Martin Nugent
01254 828060
D3/12/0790

Drafted 25 September 2012

**Planning Applications, Ribble Valley District
3/12/0790 Gamekeepers Cottage, Park Road, Gisburn**

SITE PLAN

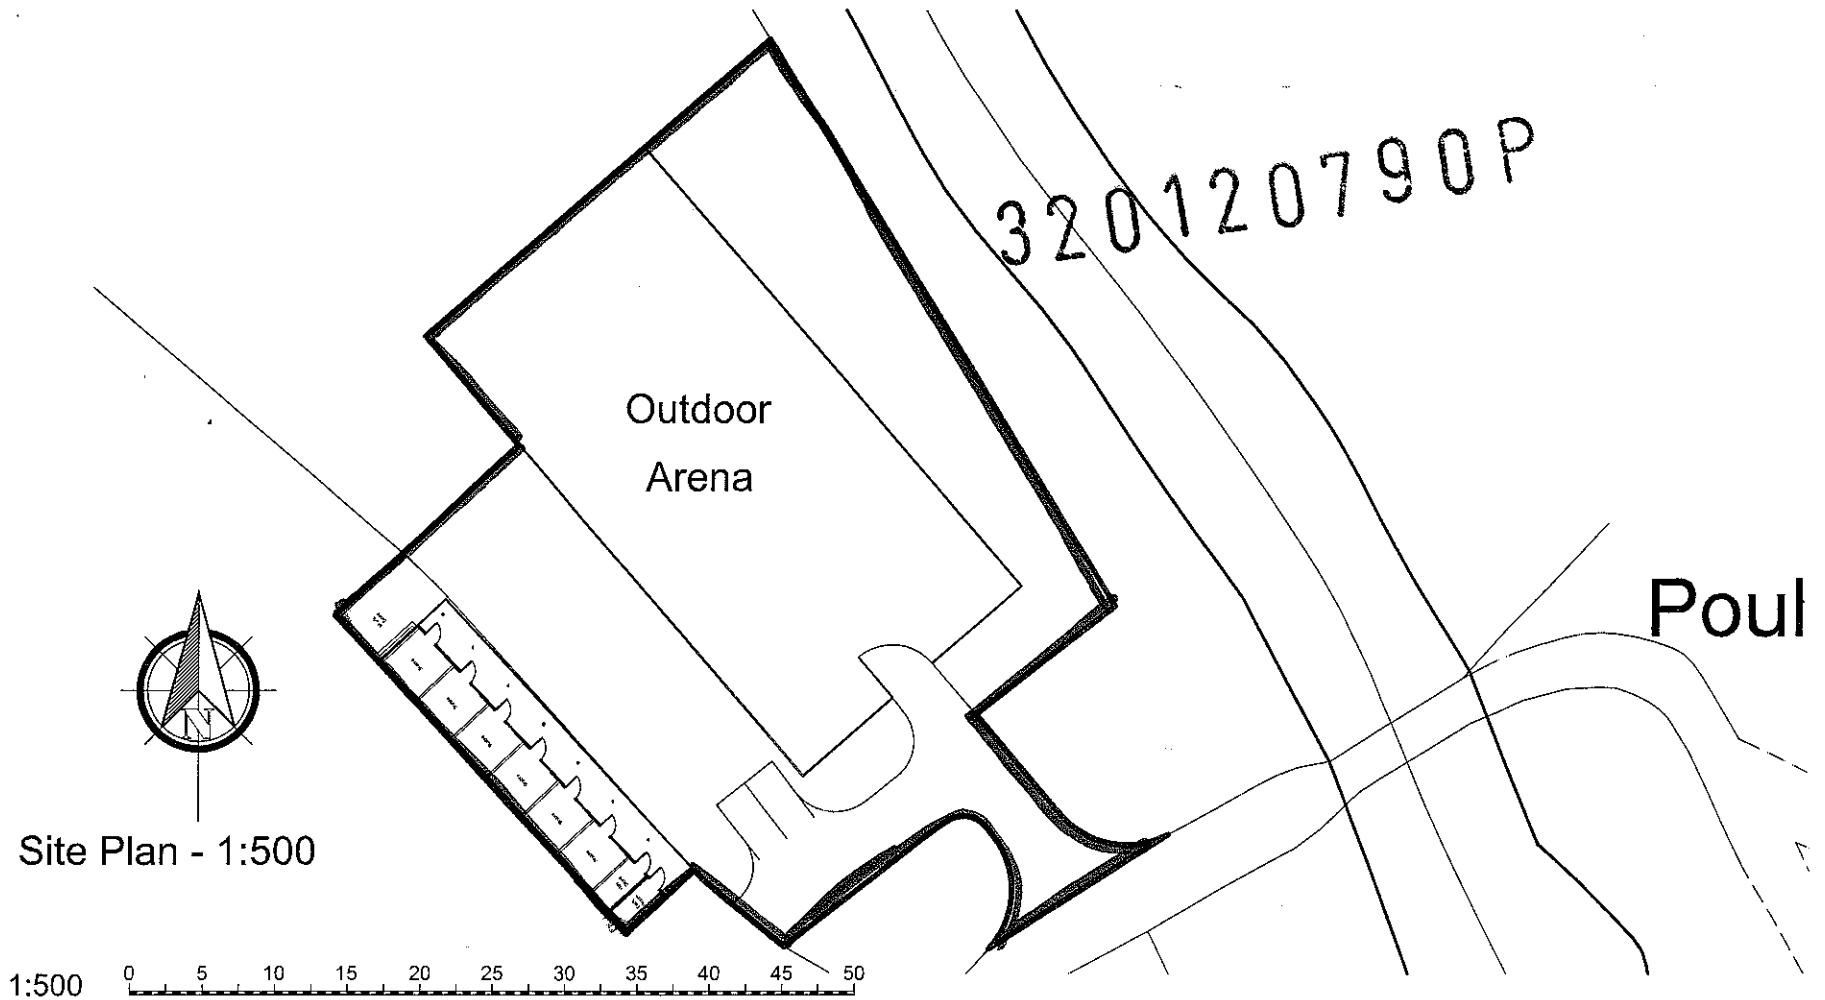
Although the application details identify no parking for the proposed development, the site layout plan shows two parking bays. I would suggest that these would be necessary for the servicing of the stable block. However, it would also be reasonable were they to provide access for visitors with mobility issues.

I would be grateful therefore if parking provisions at the proposed site are investigated further and the application amended accordingly, should this be appropriate.
